Bramford – Twinstead:

Deadline 9 Response:

Braintree District Council (20041141) &

PINS REFERENCE: EN020002

Drawing file: EN020002 / EN020002-000524-2.11.8 Design and Layout Plans Stour Valley West Cable Sealing End Compound.pdf

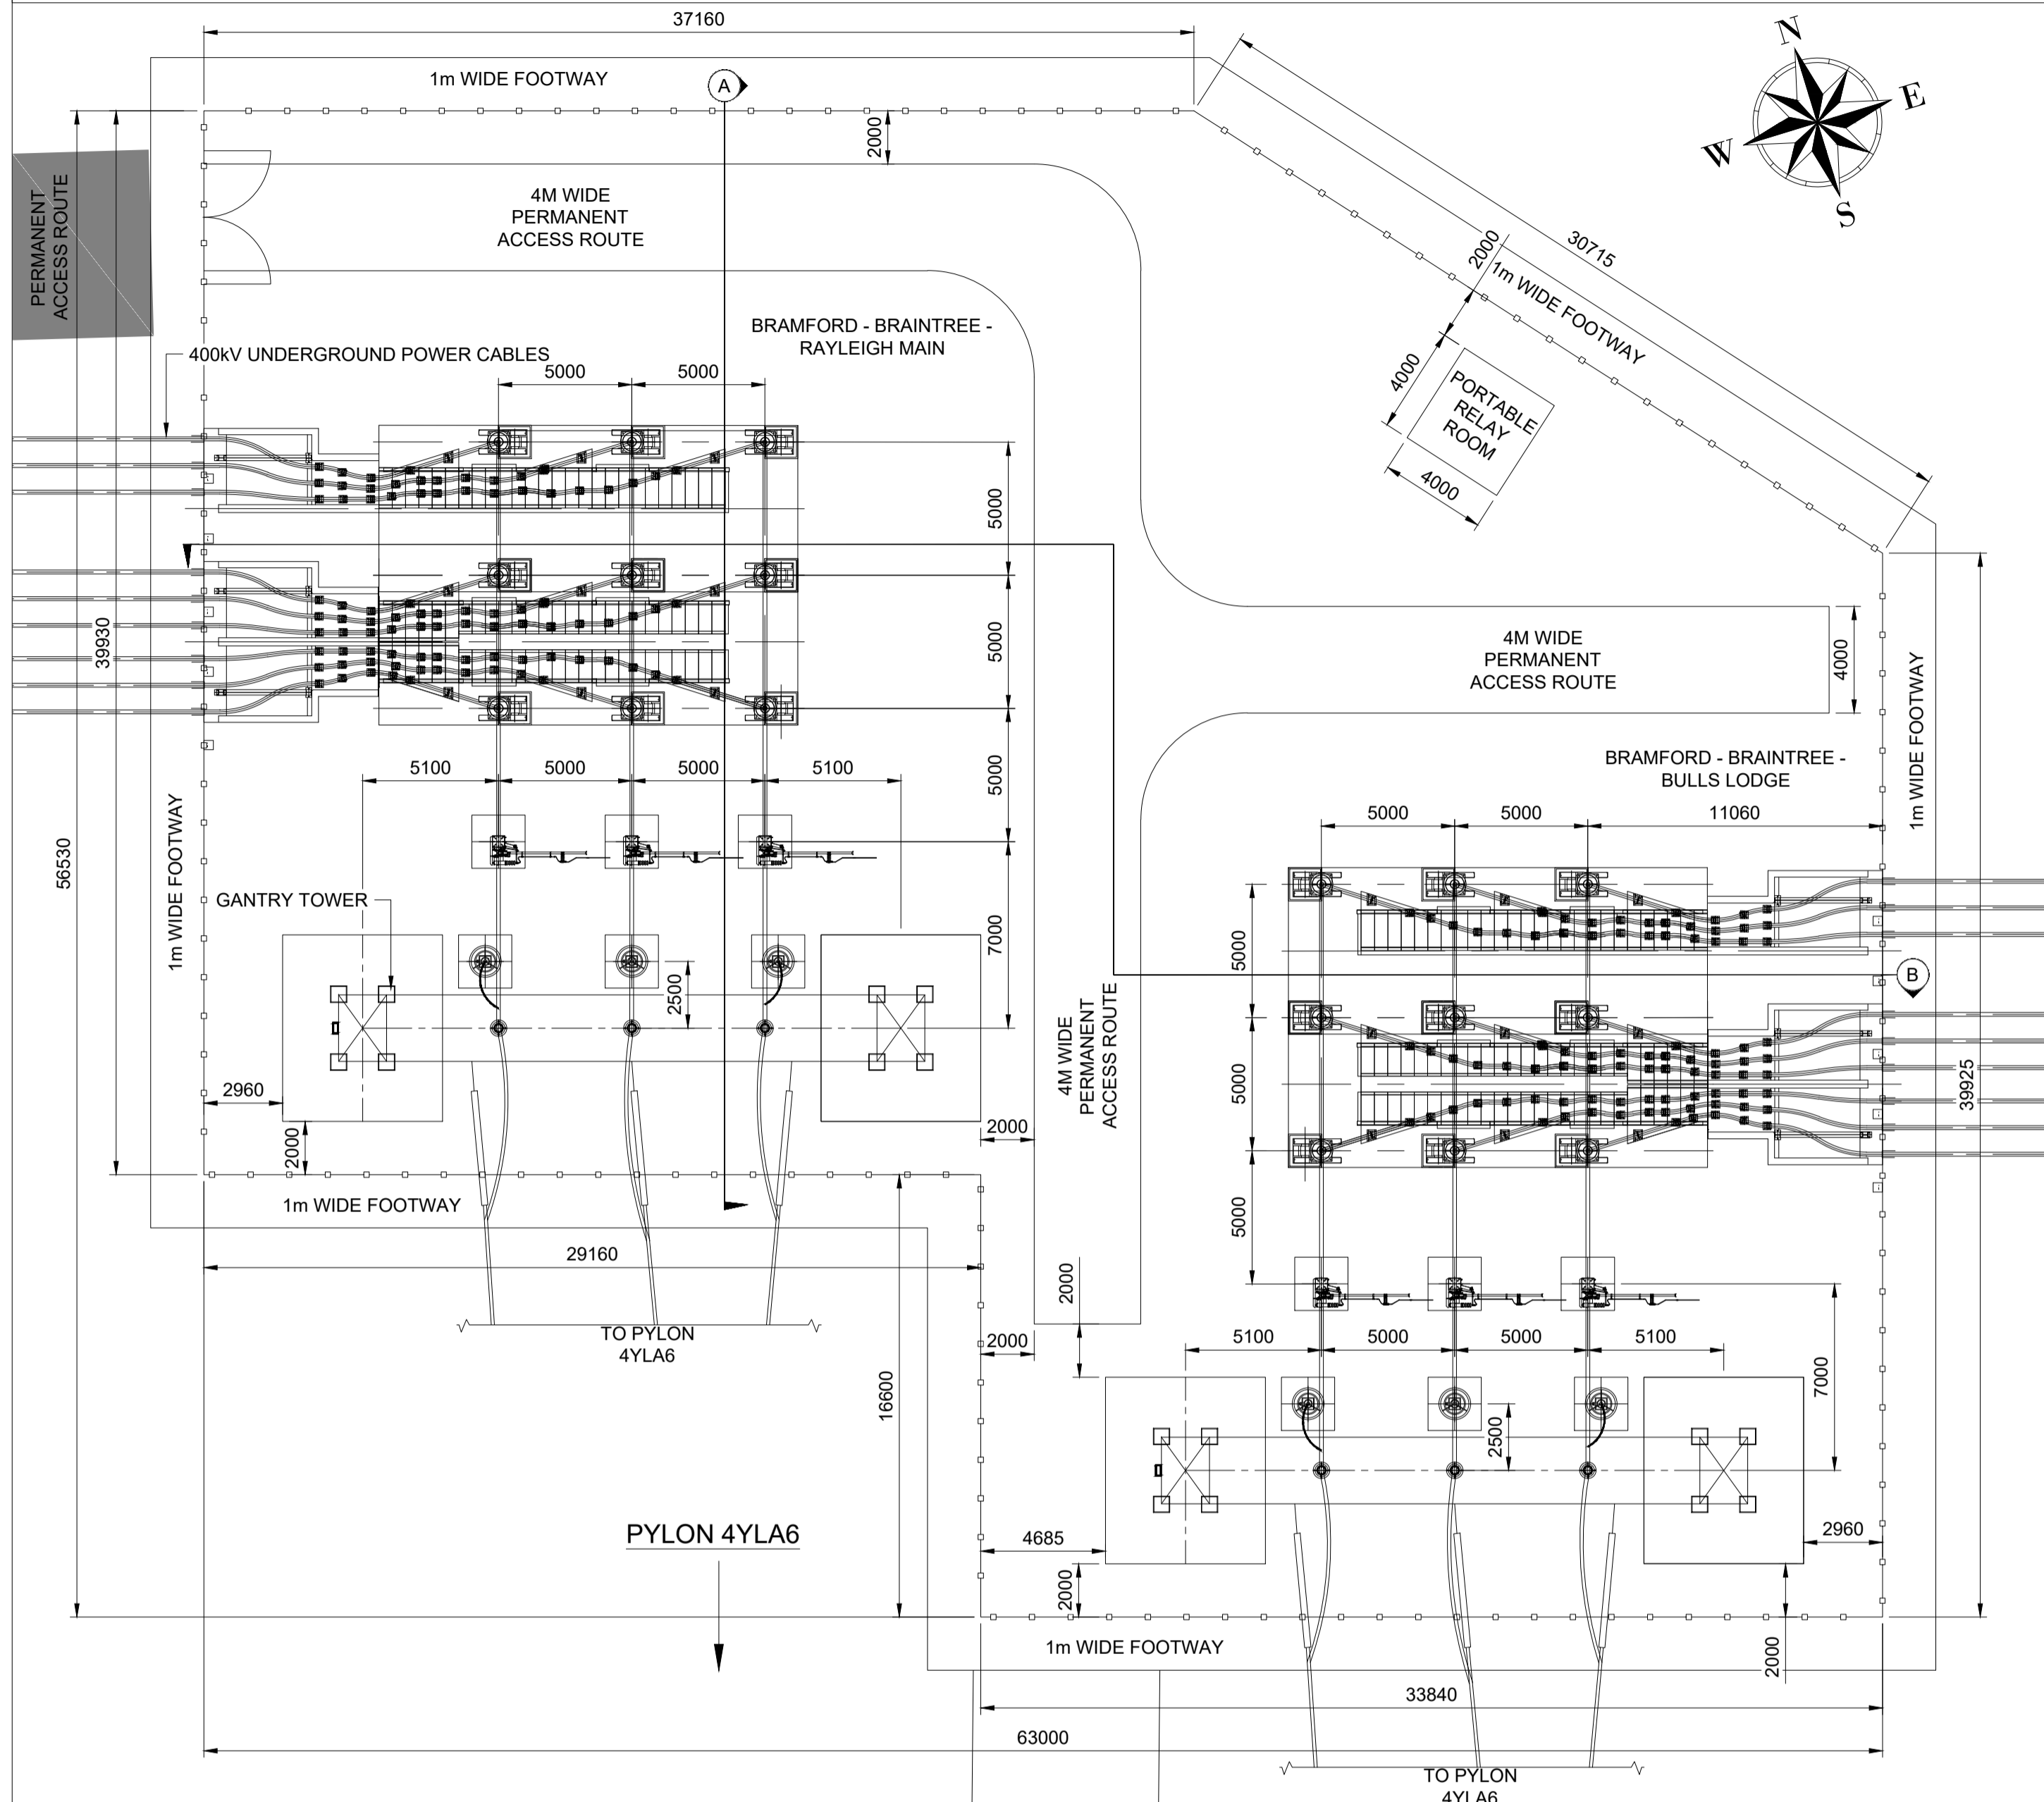
4.3.1 Stour Valley West CSE – The Councils support SCC's call for additional tree planting at Stour Valley West Cable Sealing End Compound to extend the proposed landscape softening. The Applicant talks about only needing to mitigate significant effects but The Councils maintain that as many adverse effects as possible should be mitigated or compensated for, and that the

recently published Overarching National Policy Statement for Energy (EN-1), in para 4.1.5, supports this position.
